Gatwick Airport Northern Runway Project

Examination Ref: TR020005

Joint Local Authorities Response to the Applicants Deadline 6 Submissions

Deadline 7: 15 July 2024

DRAWING TITLE  
Indicative Ecology Strategy

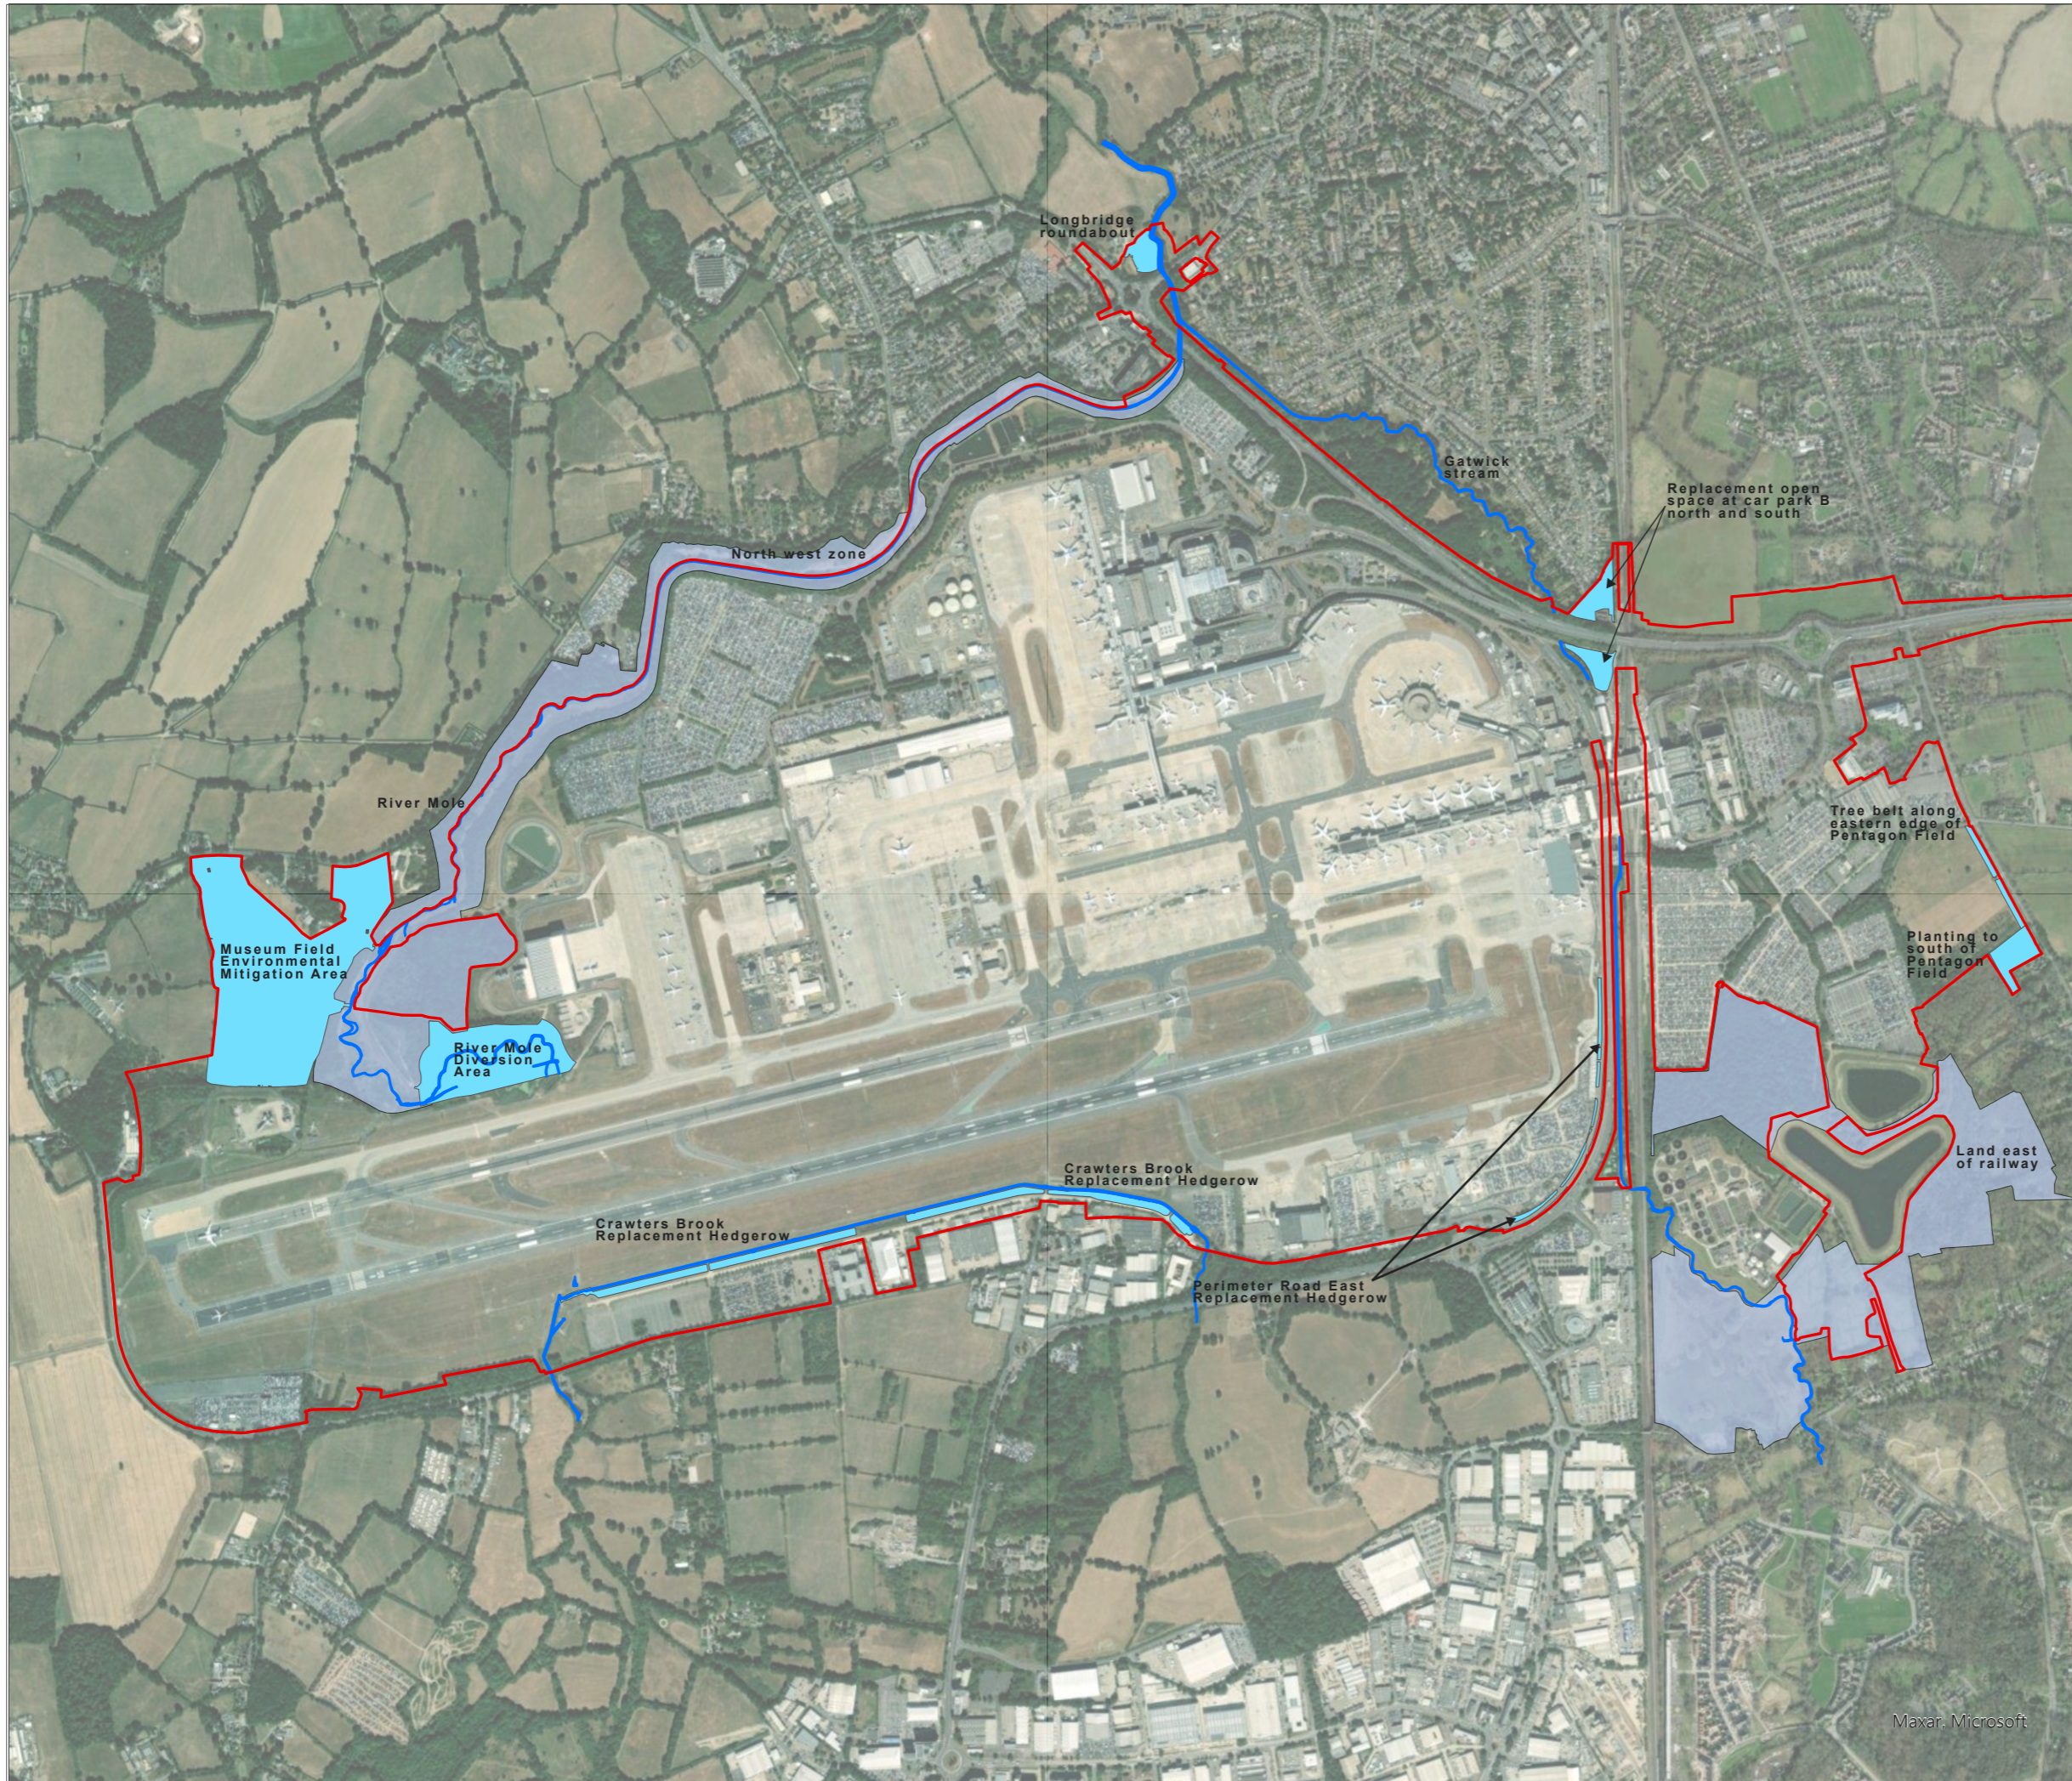
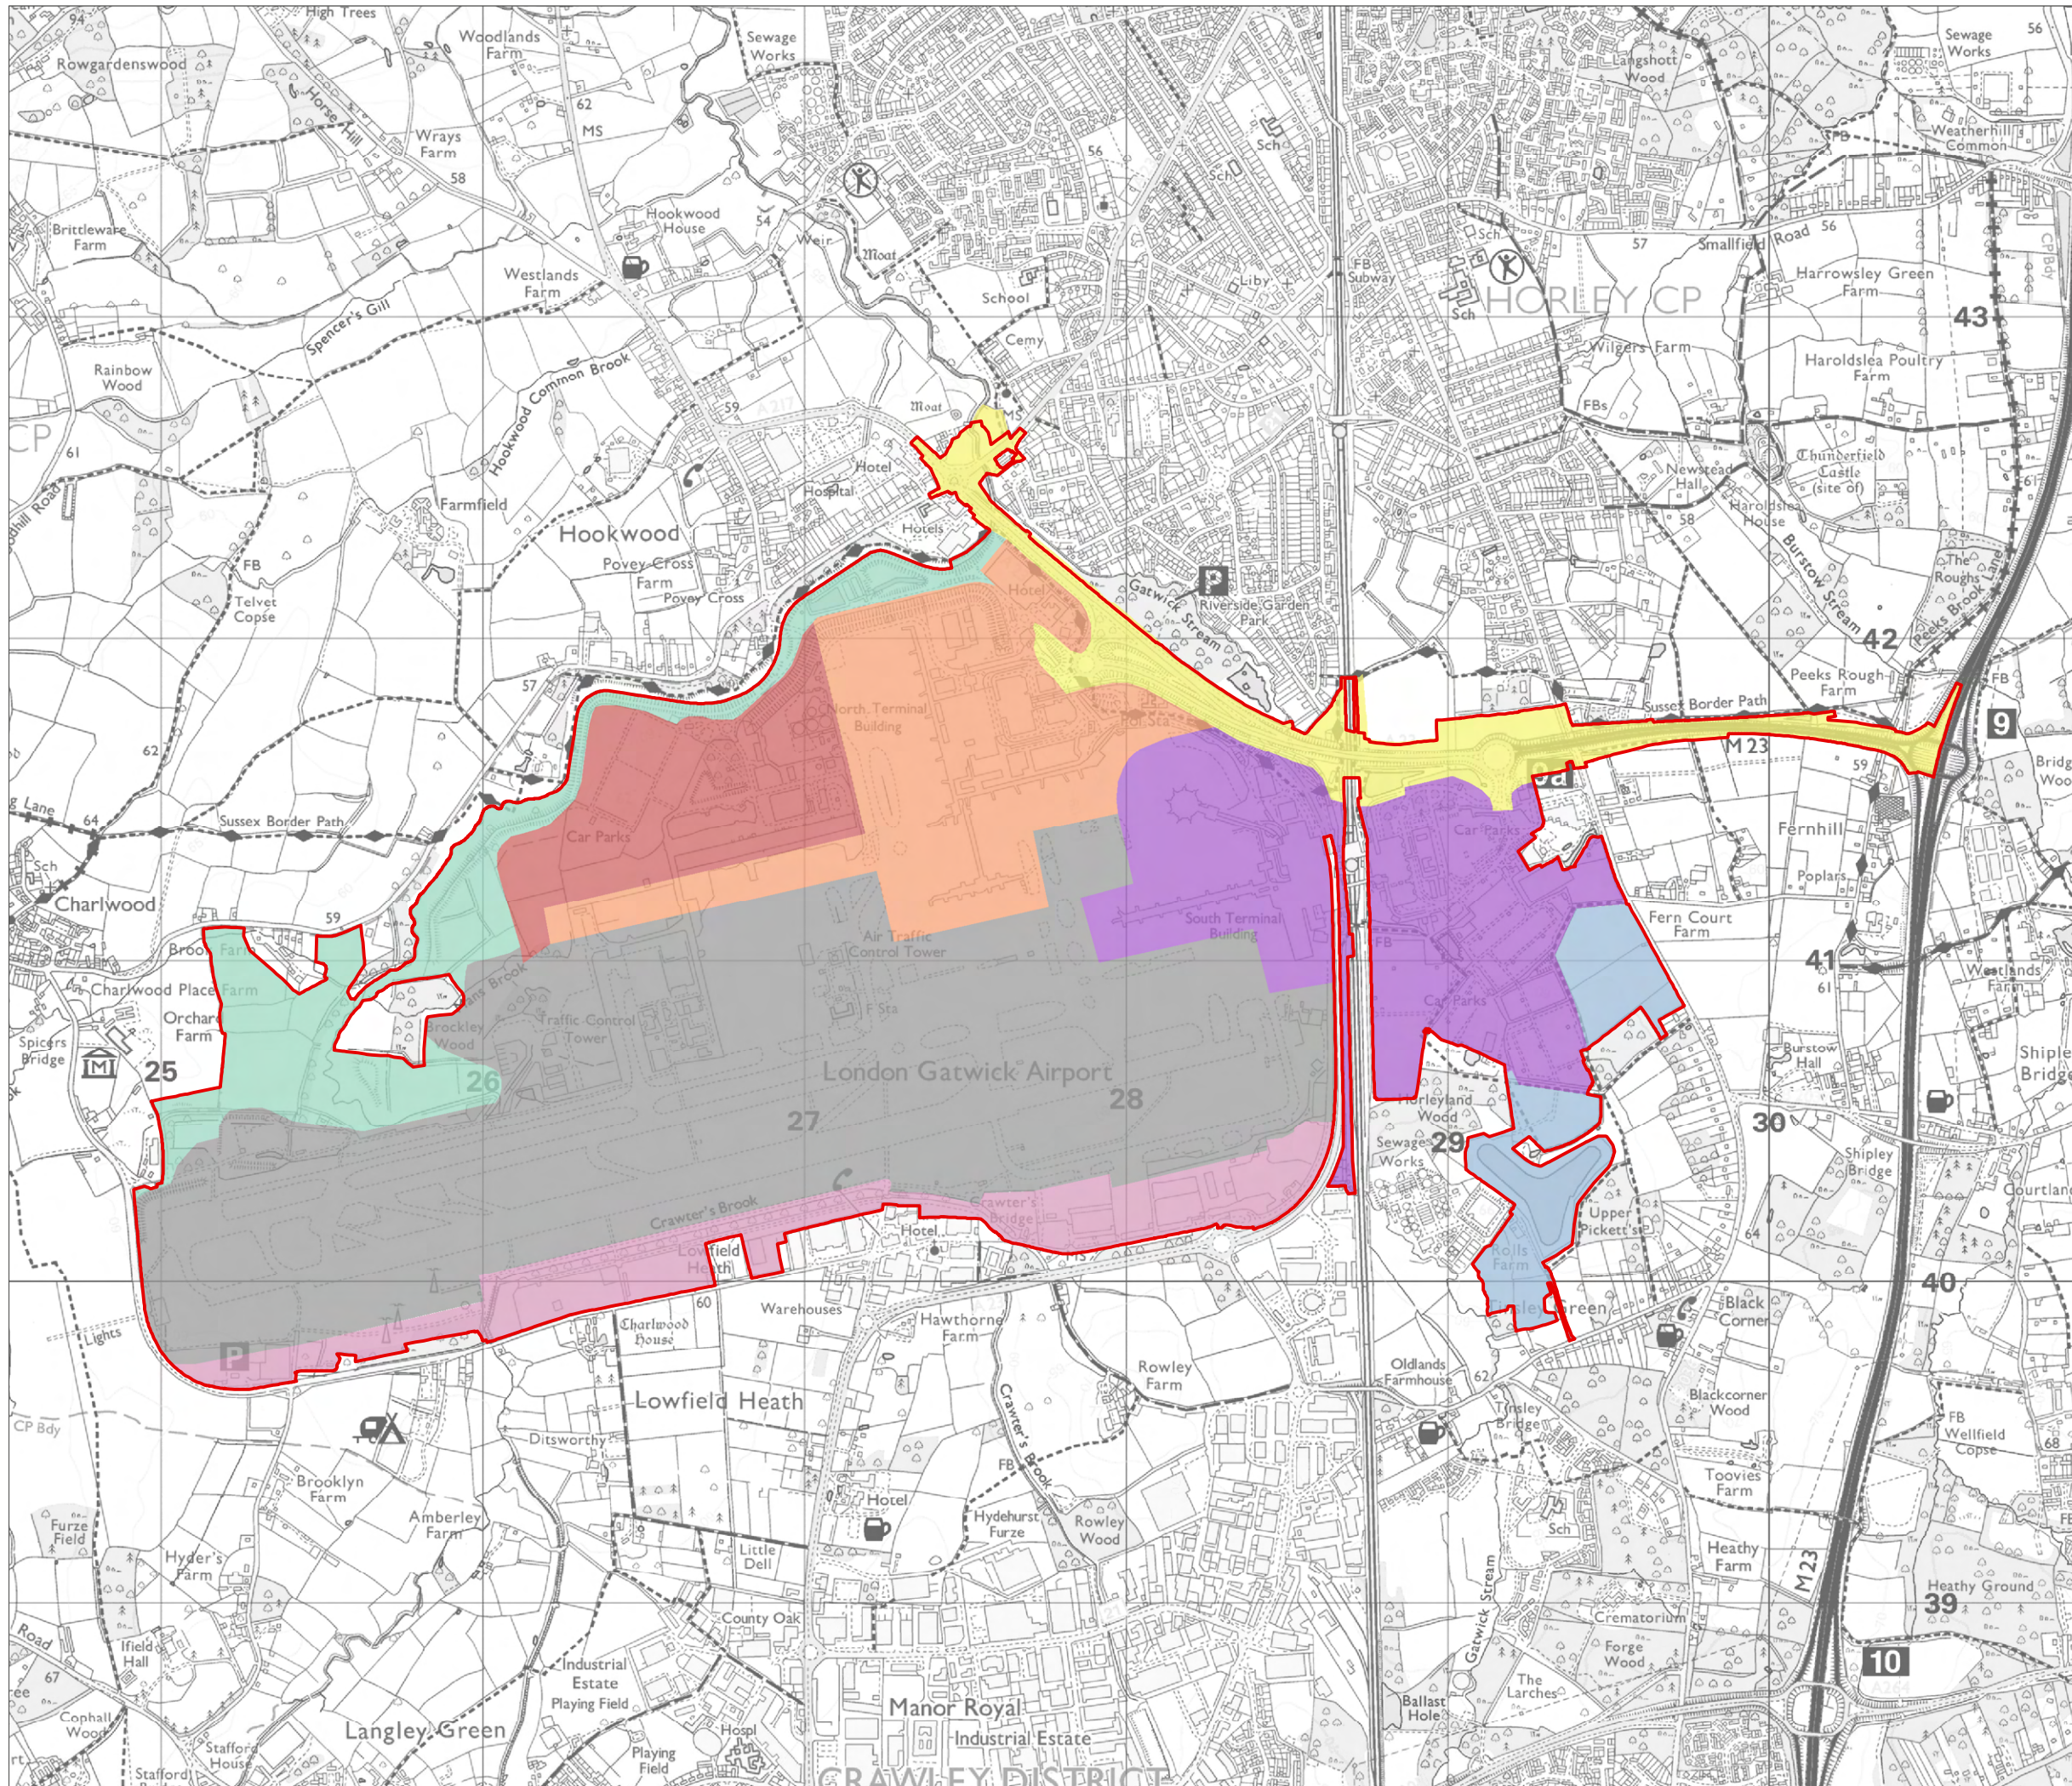
- 4.1 There is confusion as to whether Pentagon Field is to be regarded as an 'Environmental Mitigation Area'. Surprisingly it does not feature as such in Figure 3.3.1 (Indicative Ecology Strategy) dated July 2023 within the oLEMP Part 2 [REP6-034] yet sections 1.2.2 and 6.5.7 of the oLEMP Part 1 [REP6-032] state that Pentagon Field will deliver ecological mitigation or enhancement. Also, section 2.3.3 of Note on Project-Wide Habitat Loss and Replacement, June 2024 [REP6-071] refers to the creation of enhanced neutral grassland in Pentagon Field post development. If indeed Pentagon Field is to be reinstated as enhanced neutral grassland, it would be helpful if this could be made clear in all
